From: Martyn White <Martyn.White@arun.gov.uk>
Sent: 01 July 2022 17:33
To: Planning.Responses <Planning.Responses@arun.gov.uk>
Subject: AB/62/22/L

AB/62/22/L

Roof extension/mansard roof and rear Juliette balcony

PROPOSED PLAN NEW ATTIC LIVING AREA

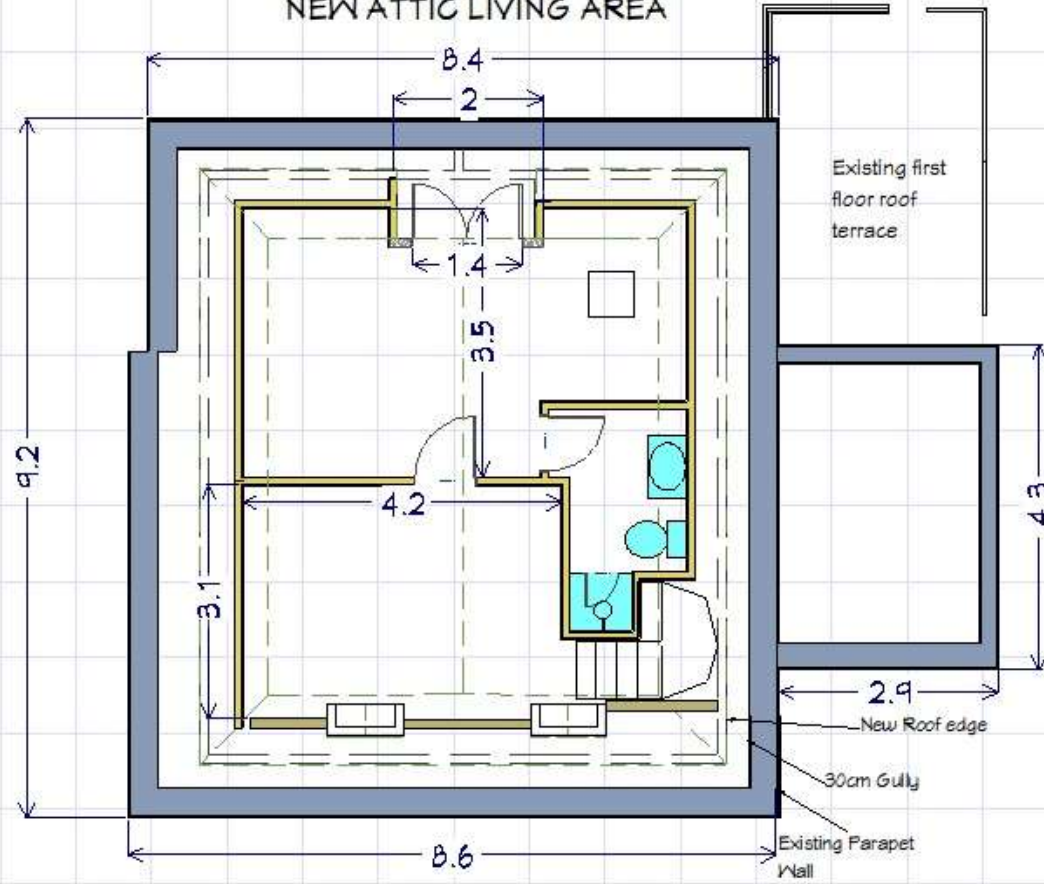
Whilst the description is to convert the (existing roof space) it would appear from the statements and plans that the actual proposal is to actually remove the existing roof and replace it with flat topped mansard roof. It is stated that this would begin 30cm inside the parapet wall and that the angle of the sloping part of the roof would be 70 degrees, and will rise 2.1 metres above the level of parapet wall. The would be a rear Juliette balcony with French window to the south (rear) and two dormers on the northern side.

In introducing the additional floor and new roof space, the proposal would alter the scale and nature of the building so that it was no longer a visually subservient structure to Tower House. The new roof will be too high and dominant and would clearly be visible from the surrounding roads. It would be unsympathetic with the design of the host property (or neighbouring terrace), where the roof is not intended to be clearly seen.

The proposal is therefore out of character and would negatively impact upon the settings of the adjoining and nearby designated heritage assets and the character and appearance of the conservation area. This element is therefore considered to be harmful.

**Proposed**

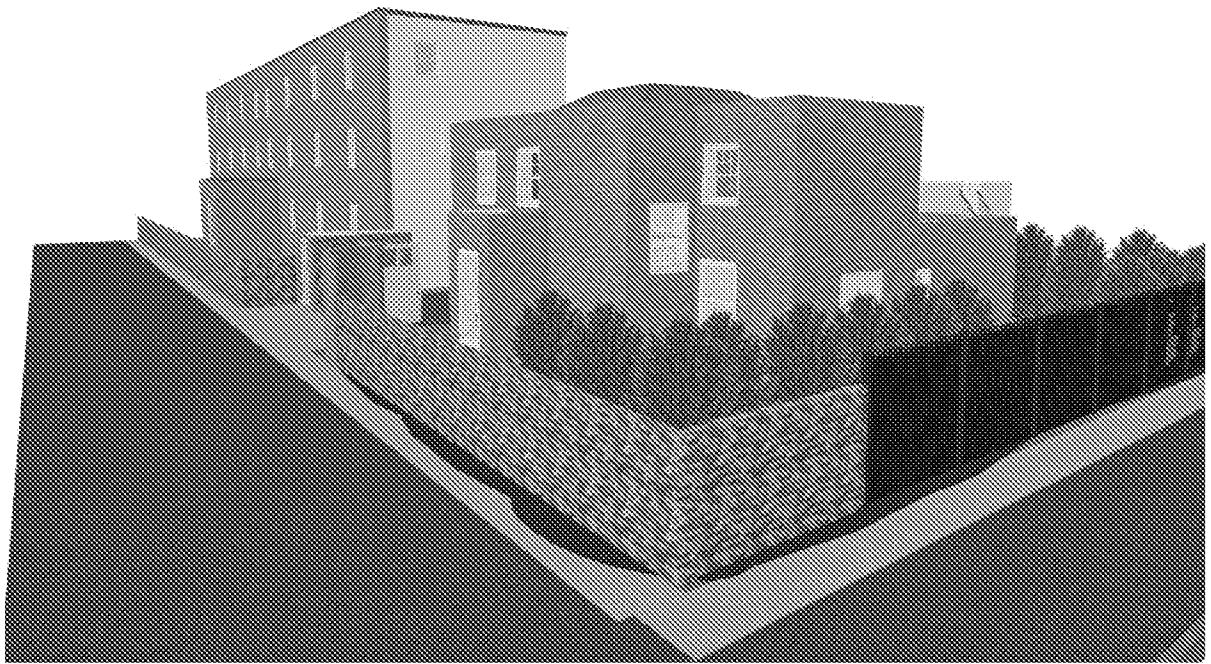
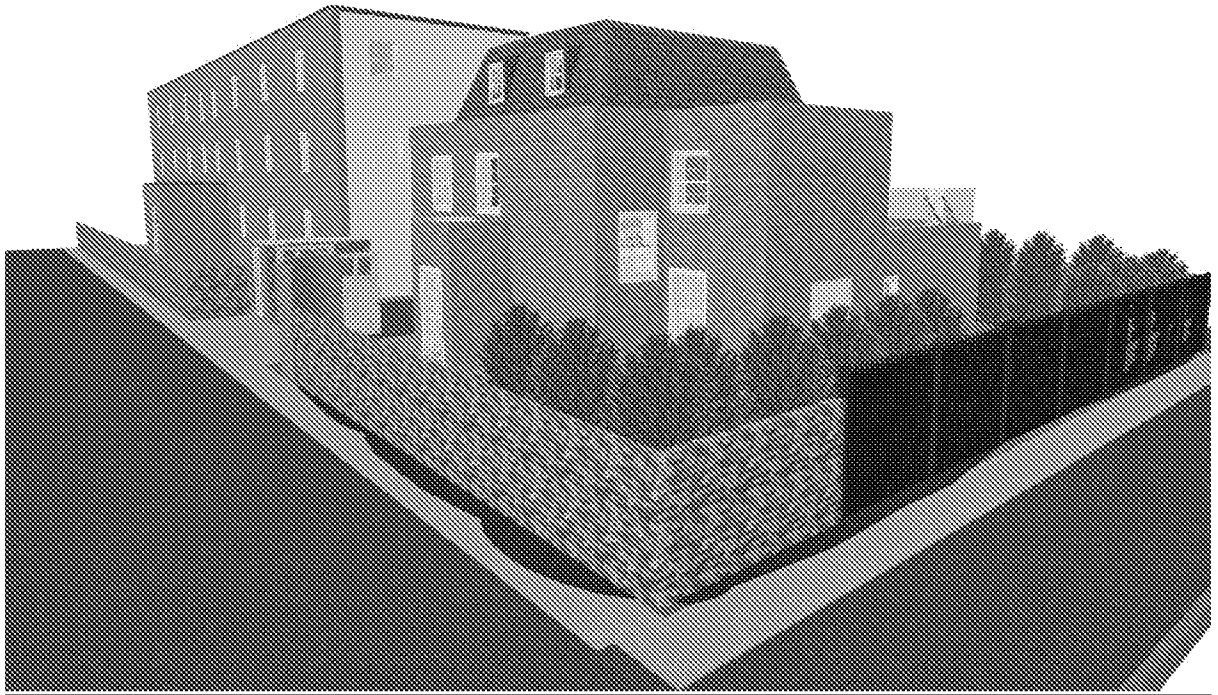
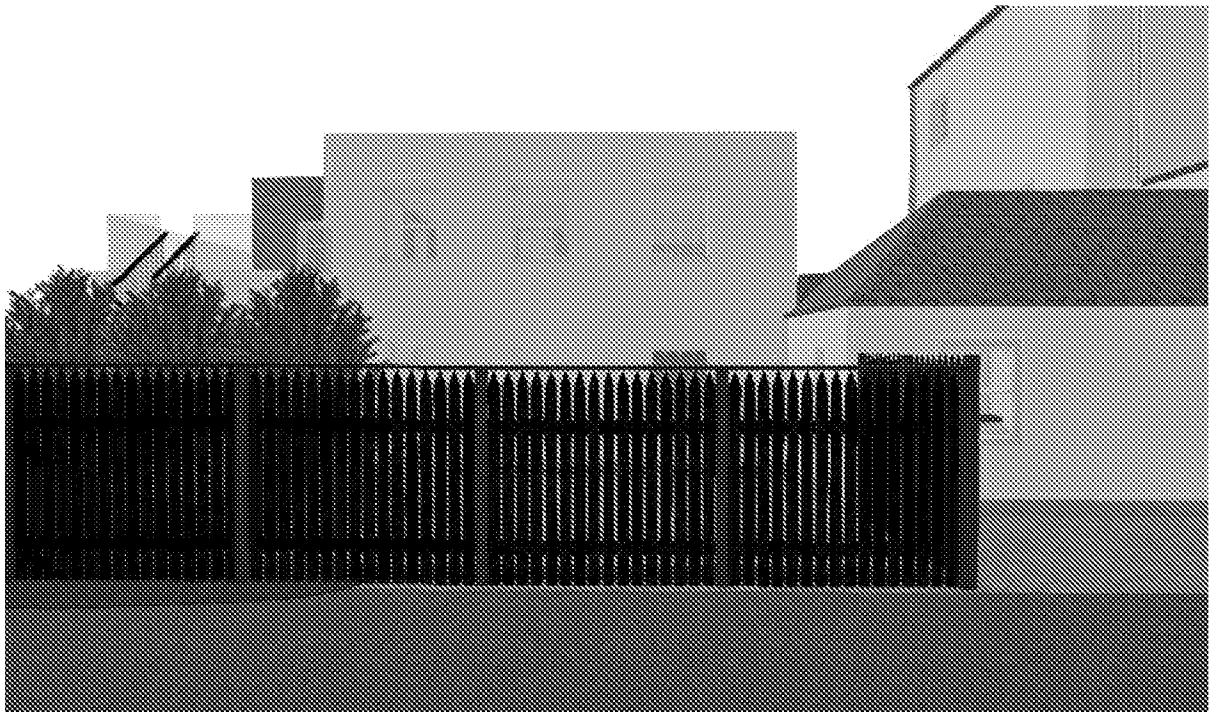
I note that the intention for the works on the northern elevation is to remove the door and ship-lap panelling on the single story extension (linking the house to Tower House), retain the window and render the wall. This seems appropriate and would be an enhancement in this particular area of the building. It is thought that the existing appearance of the shiplap is not appropriate or a style/material associated with this particular building, or its neighbour. This particular element is therefore acceptable.

Whilst the eastern elevation is identified by the applicant as being a way of enhancing the appearance of this particular elevation. As it is repeated on the neighbouring house, this elements seems to be acceptable.

I note from the Design and access Statement that the window/doors would be of a style to match the existing windows. The existing windows are UPVC, which is not really appropriate for a positive building in a conservation area, especially one such as Arundel. Ideally, new joinery should be more appropriate in terms of material. As indicated in my comments on the previous application, the replacement of the current windows on the street elevation with painted timber vertically sliding sash windows would greatly improve the appearance of the building.
